CITY OF ALBUQUERQUE

RE: Westgate Community Center Phase II
10001 De Vargas Road SW 87121
Grading and Drainage Plan
Engineer's Stamp Date: 12/22/2022
Hydrology File: M09D030

RE: Westgate Community Center Phase II
10001 De Vargas Road SW 87121
Grading and Drainage Plan
Engineer's Stamp Date: 10/21/2022
Hydrology File: M09D030

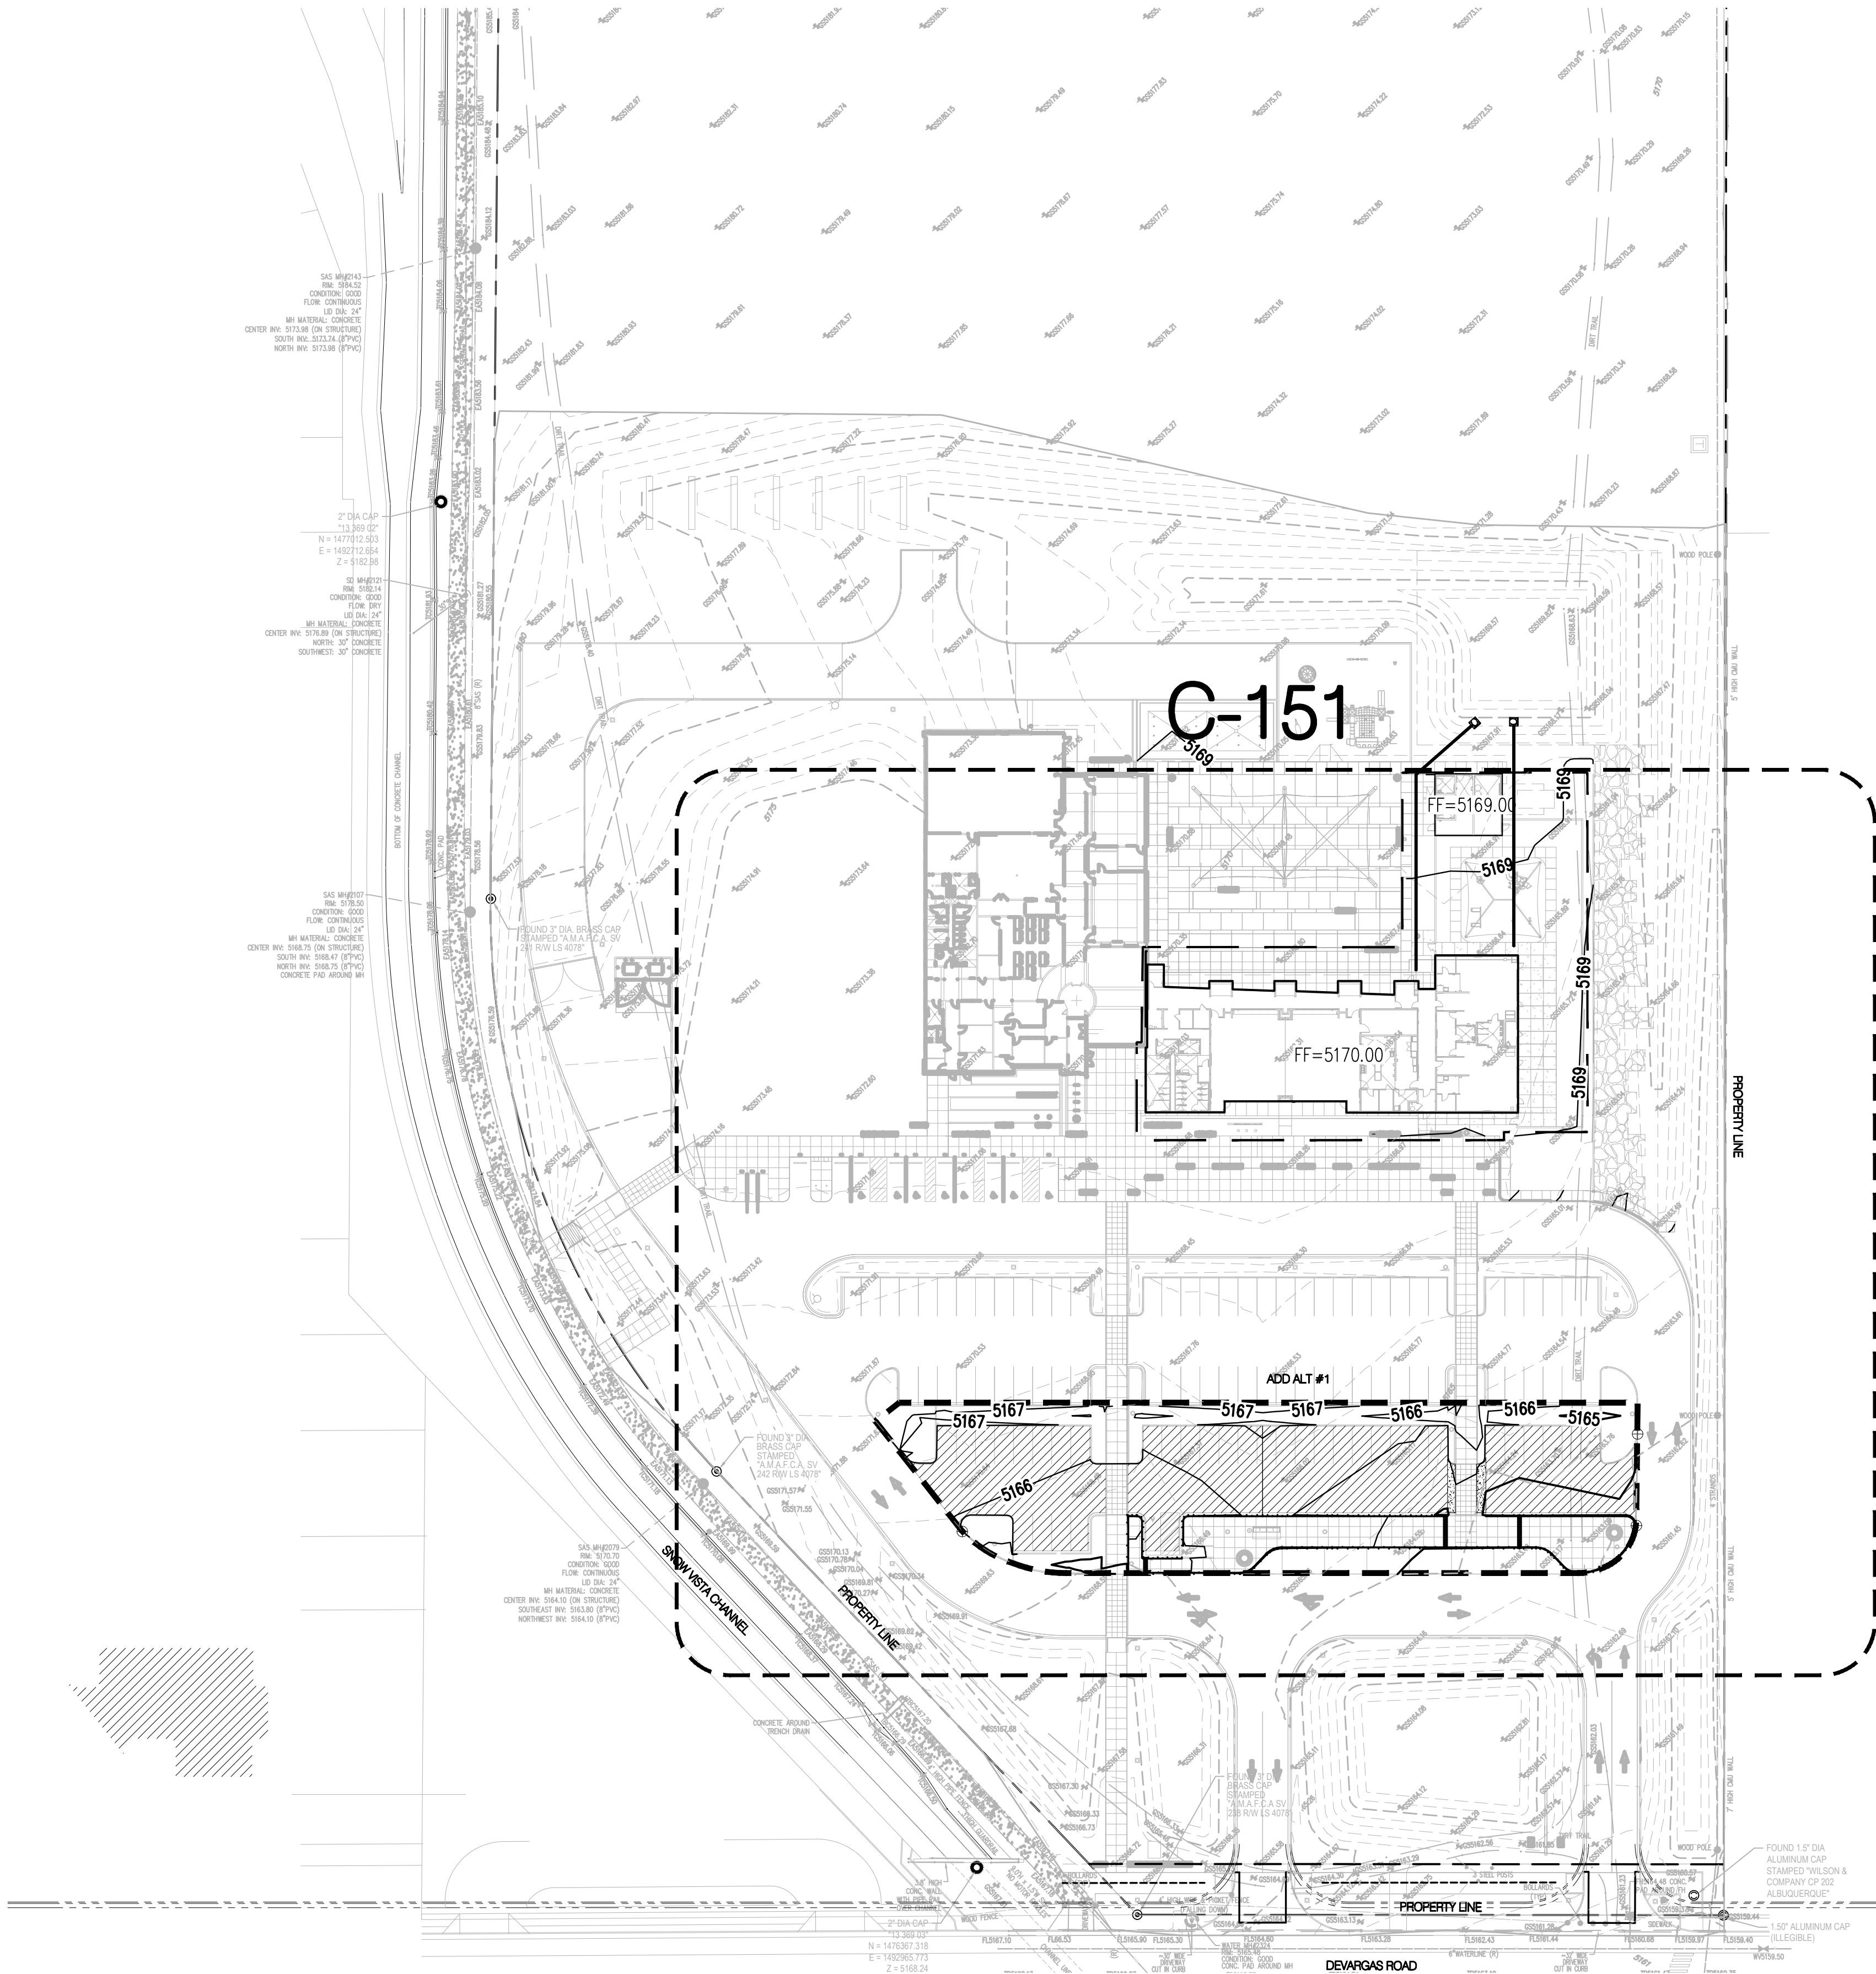
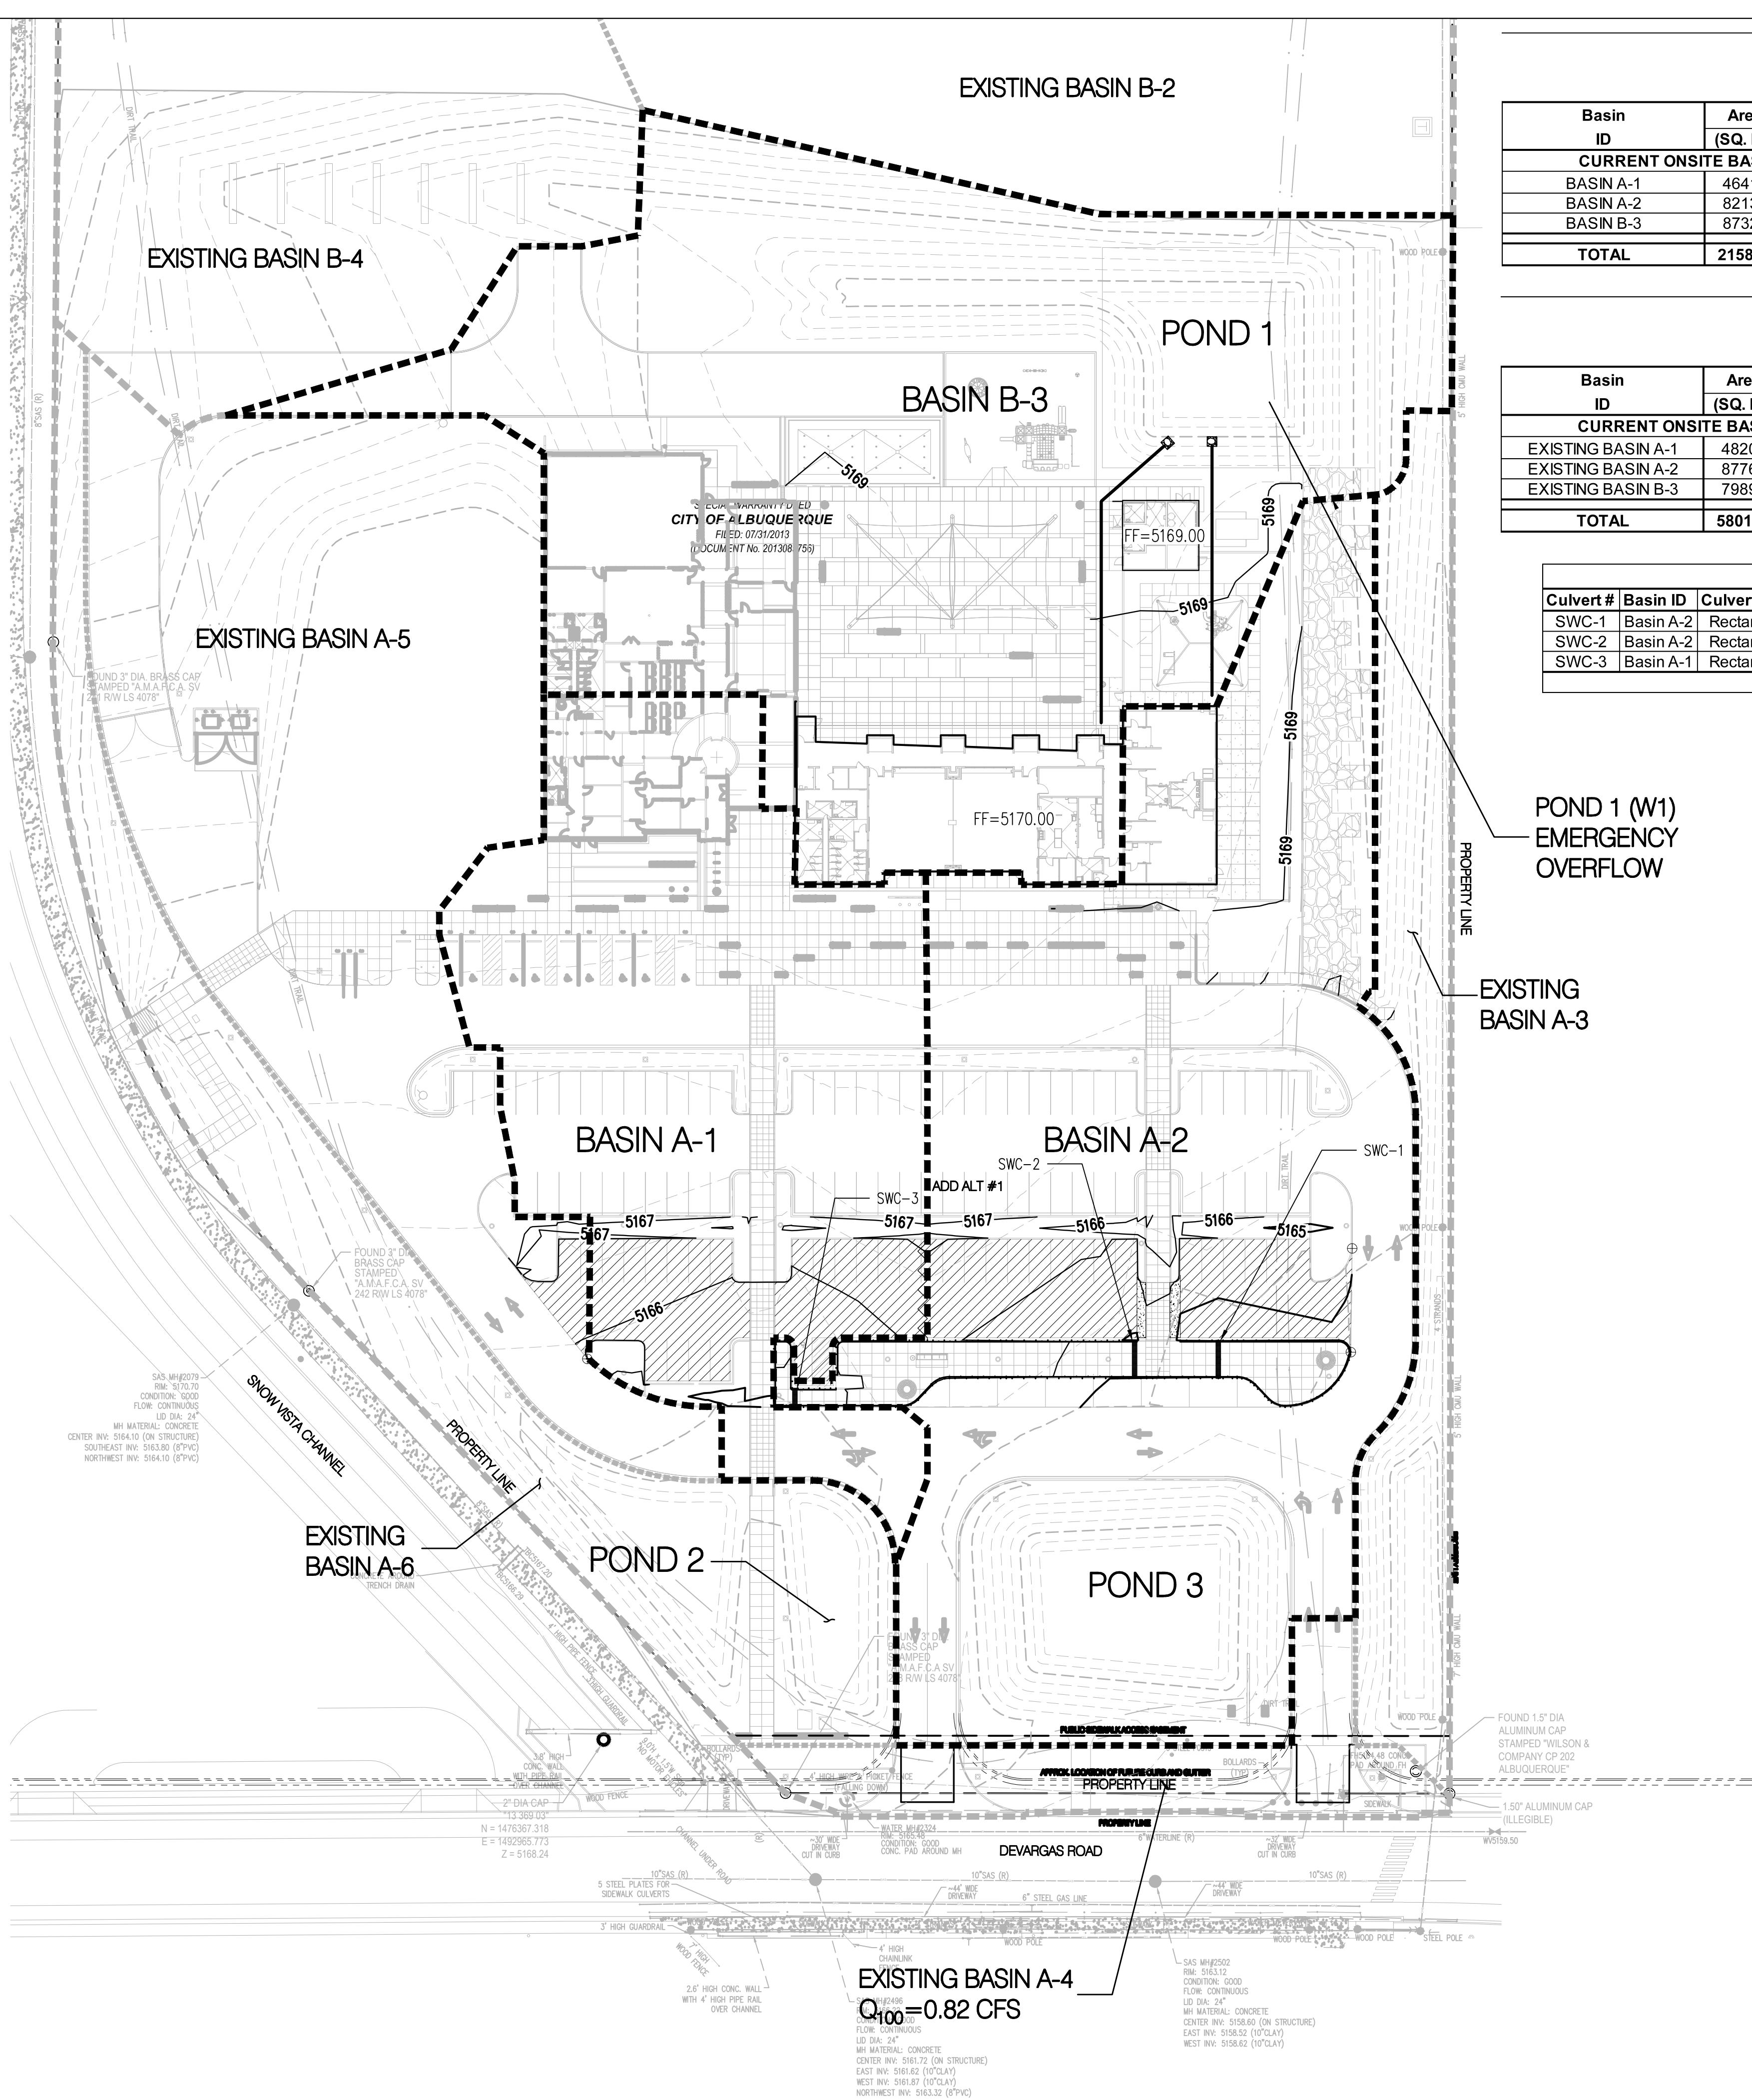
- Sheet C-001: The total numbers (highlighted) for both proposed and existing conditions do not match with the summary of the sub-basins' numbers. Please verify. Has pond 3 already been built? If so, delete "Future" in pond data table. Indicate the sidewalk culverts locations or delete the sidewalk culvert table if they are not a part of this phase.

- *The populated quantities for Pond 1's required volume is based on the summation of the volumes for Basins B-1, B-2, and B-4 from already approved Phase I Drainage Management Plan in addition to Basin B-3 which can be seen on sheet C-001. Adding these values together we can see that the total volume required for Pond 1 is equal to $1554 \text{ CF} + 13914 \text{ CF} + 11138 \text{ CF} + 4359 \text{ CF} = 30965 \text{ CF}$ which is what is shown on sheet C-001.*

- *The populated quantities for Pond 2's required volume is based on the summation of the volumes for Basins A-5 and A-6 from the already approved Phase I Drainage Management Plan in addition to Basin A-1*

which can be seen on sheet C-001. Adding these values together we can see that the total volume required for Pond 2 is equal to $7916 \text{ CF} + 8161 \text{ CF} + 2461 \text{ CF} = 18538 \text{ CF}$. This total volume required for Pond 2 was previously showing an incorrect value and has been updated to show 18538 CF.

- The populated quantities for Pond 3's required volume is based on the summation of Basin A-2 which can be seen on sheet C-001 and the overflow volume from Pond 2. Adding these two values together we can see that the total volume required for Pond 3 is equal to $13567 \text{ CF} + (18538 \text{ CF} - 9585 \text{ CF}) = 22520 \text{ CF}$. This total volume required for Pond 3 was previously showing an incorrect value and has been updated to show 22520 CF.
- Pond 3 has in fact already been built so the "Future" located in the Pond Data Table has been removed.
- The sidewalk culvert locations are in fact located on sheet C-001. A snip of the referenced locations has been shown below for clarification.
